**RE: 11906 San Antonio Dr. NE
Grading & Drainage Plan
Engineer's Stamp Date: 07/09/21
Hydrology File: E22D007H2**

RE: 11906 San Antonio Dr. NE
Grading & Drainage Plan
Engineer's Stamp Date: 06/10/21
Hydrology File: E22D007H2

Based upon the information provided in your submittal received 06/10/2021, the Grading & Drainage Plan **is not** approved for Grading Permit. The following comments need to be addressed for approval of the above referenced project:

ENGINEER'S SEAL	TRACT C-2-A-1-A SAUVIGNON SUBDIVISION	DRAWN BY WCVJ
		DATE 5-21-21
	GRADING AND DRAINAGE PLAN	210210054-LAYOUT-5-20-21
	6/10/21	 <div>Rio Grande Engineering 1606 CENTRAL AVENUE SE SUITE 201 ALBUQUERQUE, NM 87106 (505) 872-5999</div>
DAVID SOULE P.E. #14522	JOB # 21021054

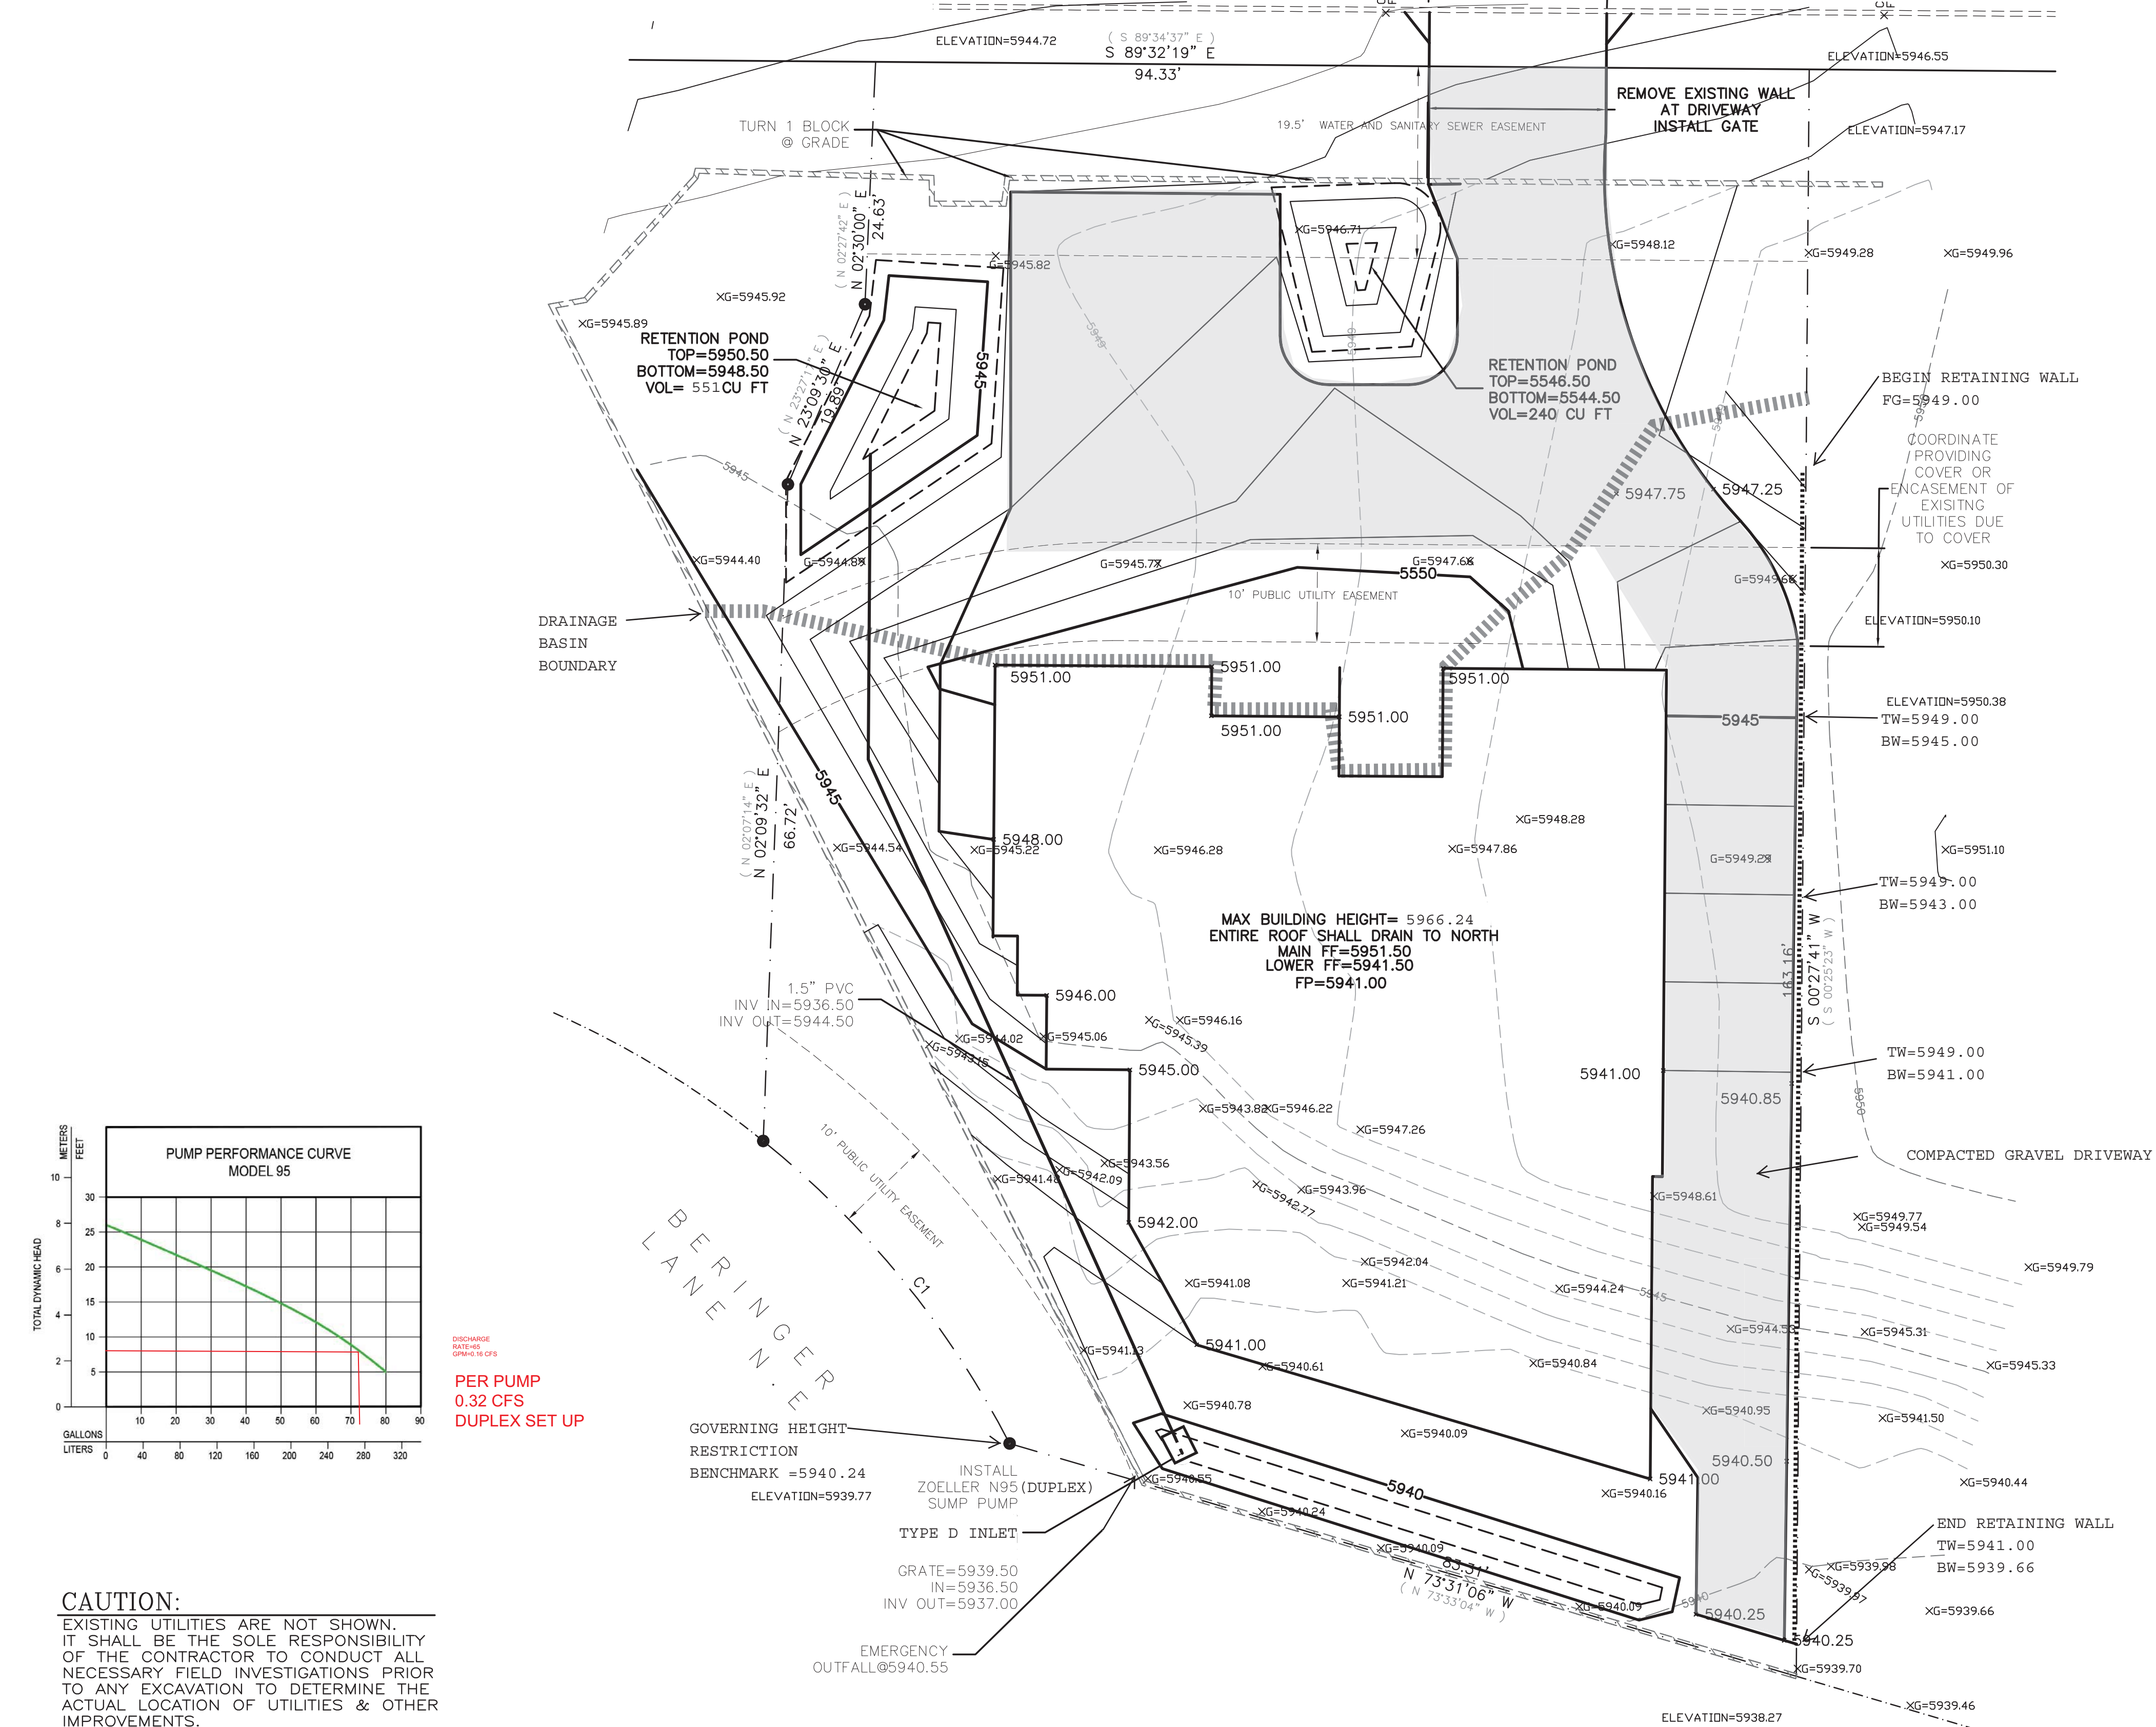
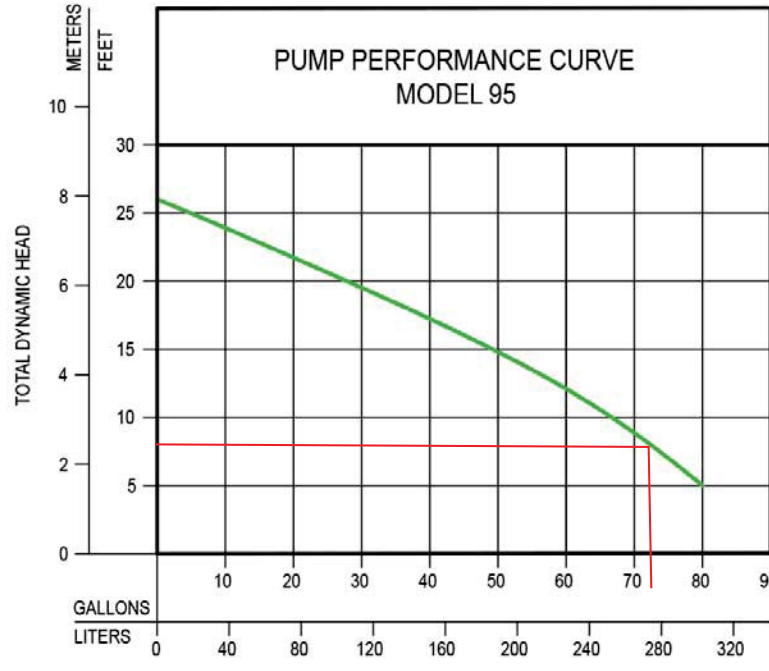
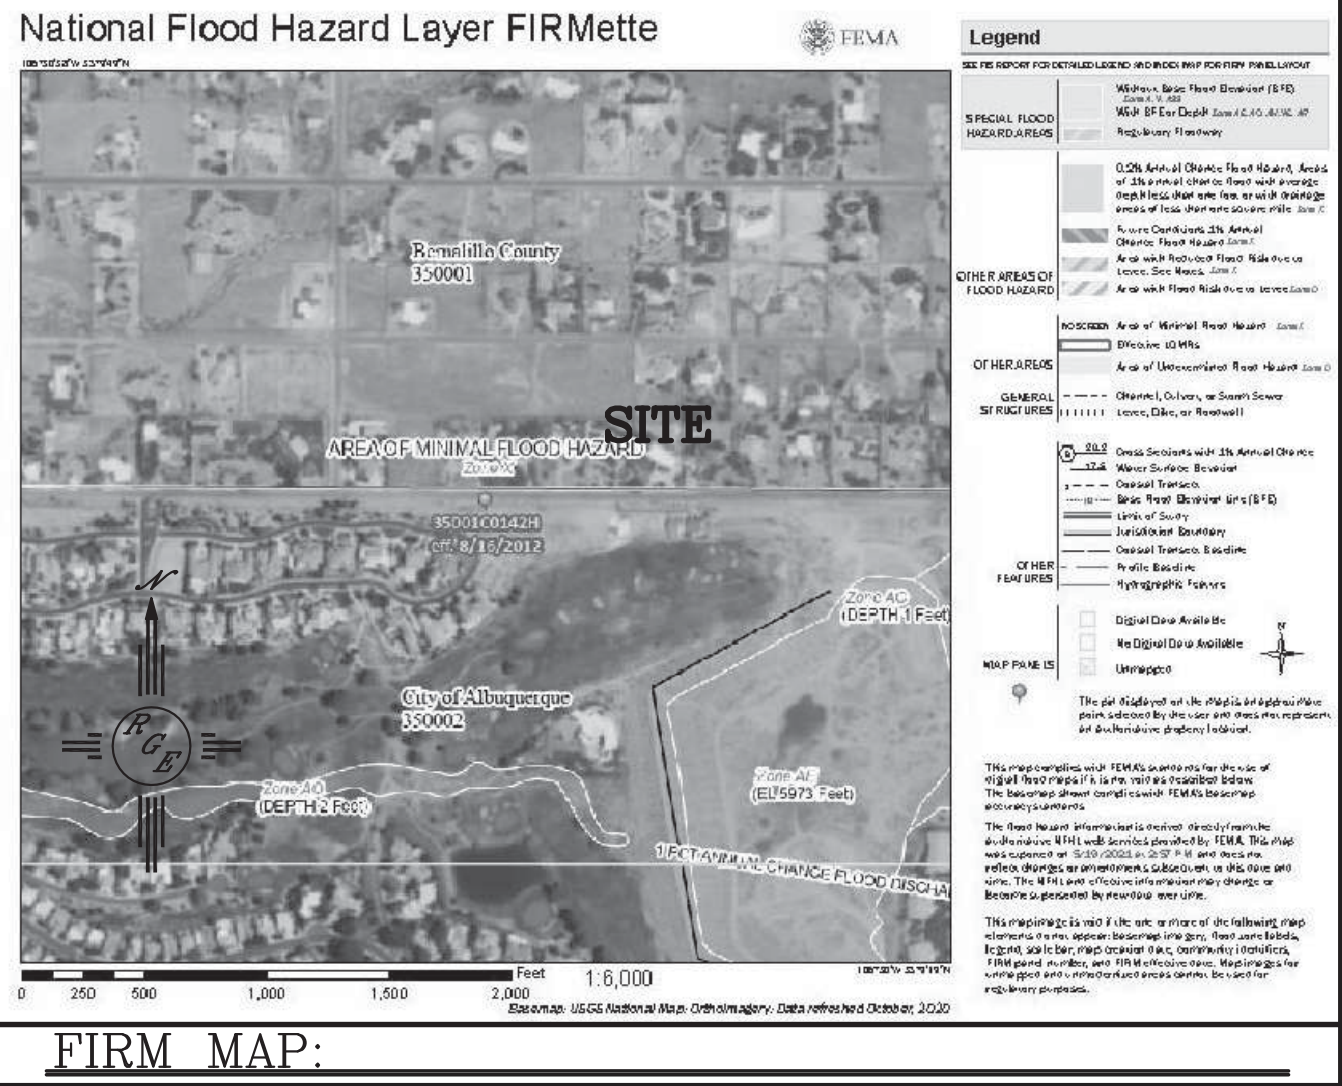
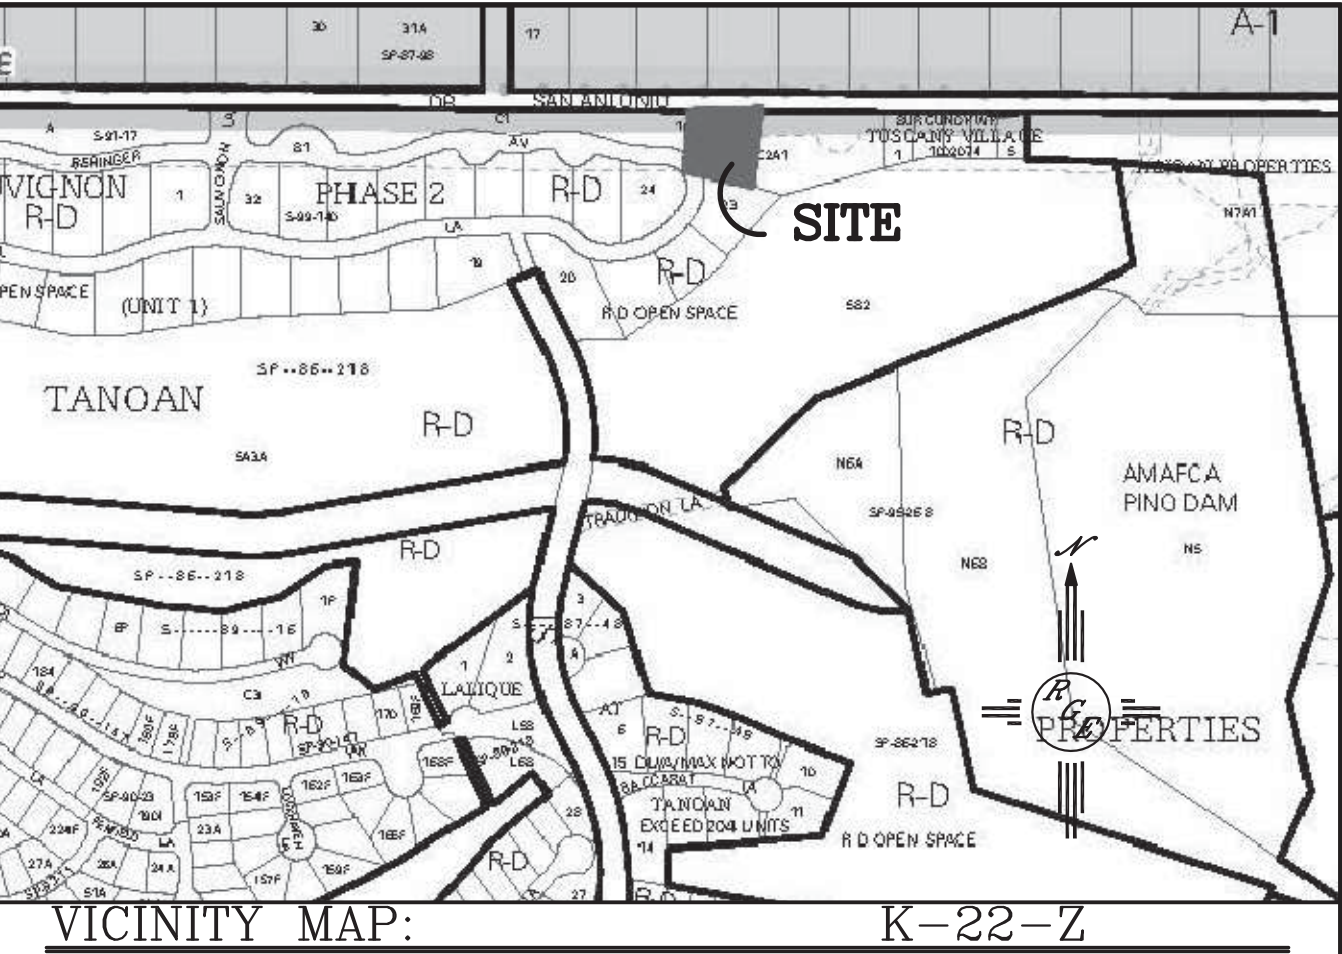
1. Please provide the existing 65 feet PNM Easement in the front of the property. Also please show the existing overhead power lines. (See Below) **ADDED, ACCORDING TO PLAT AND SURVEY IT OVERLAPS THE ACCESS EASEMENT THAT IS SAN ANTONIO**

2. The house needs to be relocated out of the existing 65 feet PNM Easement. (See Below) **HOUSE DOES NOT ENCROACH, NORTH EDGE OF 65' EASEMENT DOES NOT CORRESPOND TO PROPERTY LINE, EASEMENT HAS BEEN SHOW PER SURVEY AND PLAT**

- Per the approval letter for Prichard Subdivision dated December 17, 2018 (Attached), Hydrology will need written permission from PNM for any grading within their 65 feet Easement. **IF PLAN IS ACCEPTABLE, PERMISSION WILL BE OBTAINED AND WE PROPOSE AT PAD CERT**
- Also according the approved Conceptual Grading & Drainage Plan for Prichard Subdivision (E22D007H), a retention pond is required to hold the 100yr-6hr storm. (See Below) Therefore this lot needs a retention pond volume of 657 CF. **WE HAVE INCREASED RETENTION VOLUME AS REQUIRED**

- The proposed drainage narrative provided violated this previous approved Conceptual Grading & Drainage Plan for Prichard Subdivision. (See Below) Therefore this will have to conform with this plan. **WE HAVE REVISED NARRATIVE**
